# Rezoning Transportation Analysis

Petition Number: 2024-008

## Revision Log:

Date	Description
2-21-24	First Review (NK)
3-20-24	Second Review (NK)
4-24-24	Third Review (NK)

RZ01 - REZONING PLAN

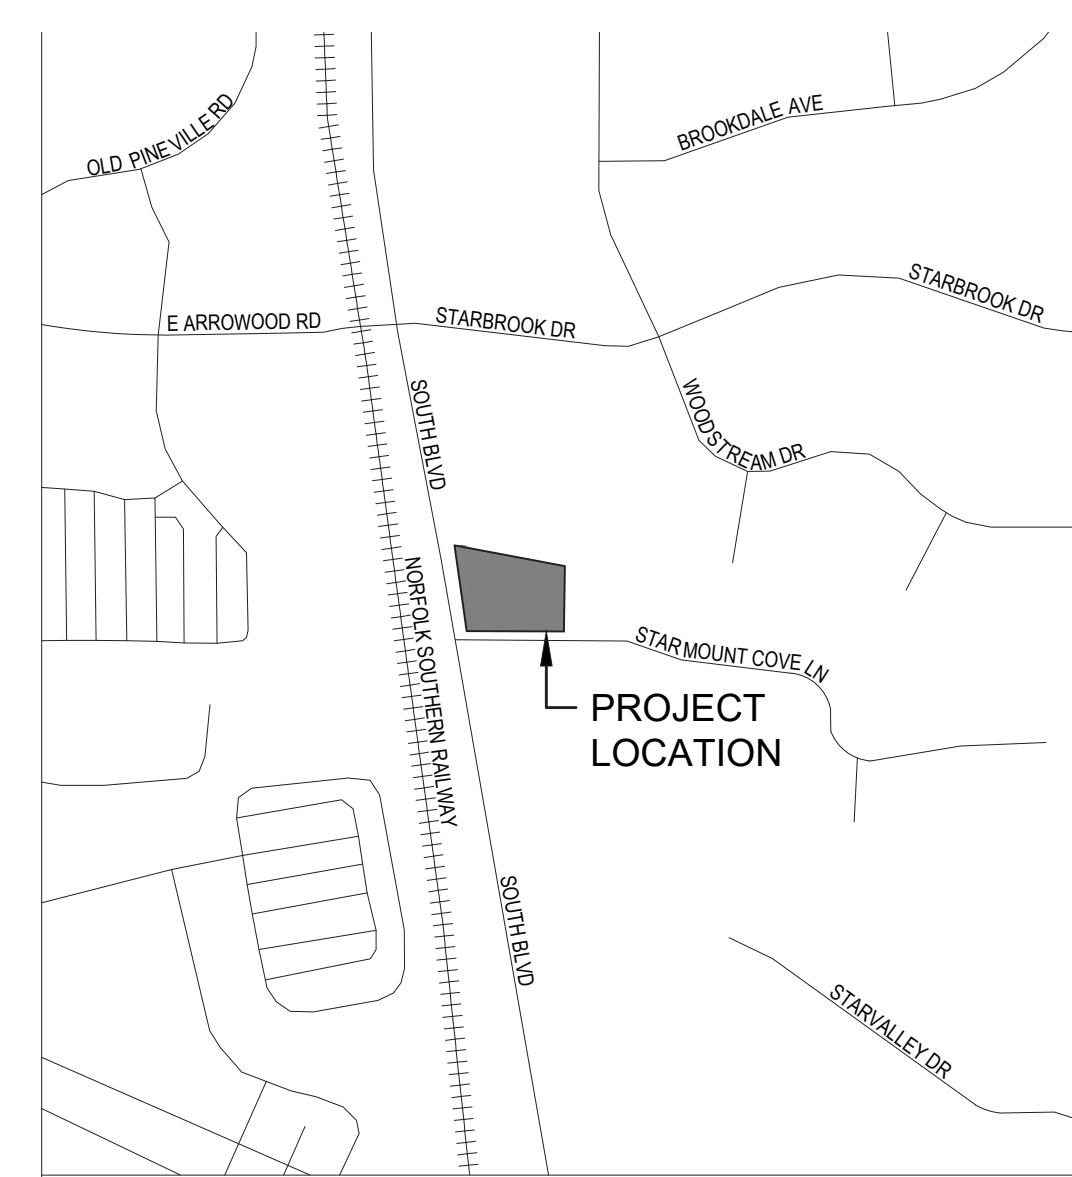
11. **New Comment 4.24.24:** Add a conditional note to commit to installing 8’ sidewalk and an 8’ planting strip along South Blvd and Starmount Cove Lane as shown on plans.

12. **New Comment 4.24.24:** Please clarify on plans if the existing curb is remaining or if it is being relocated to future back of curb. Curb relocation is not required, but the sidewalk and planting strip should continue to be shown based on future curb location.
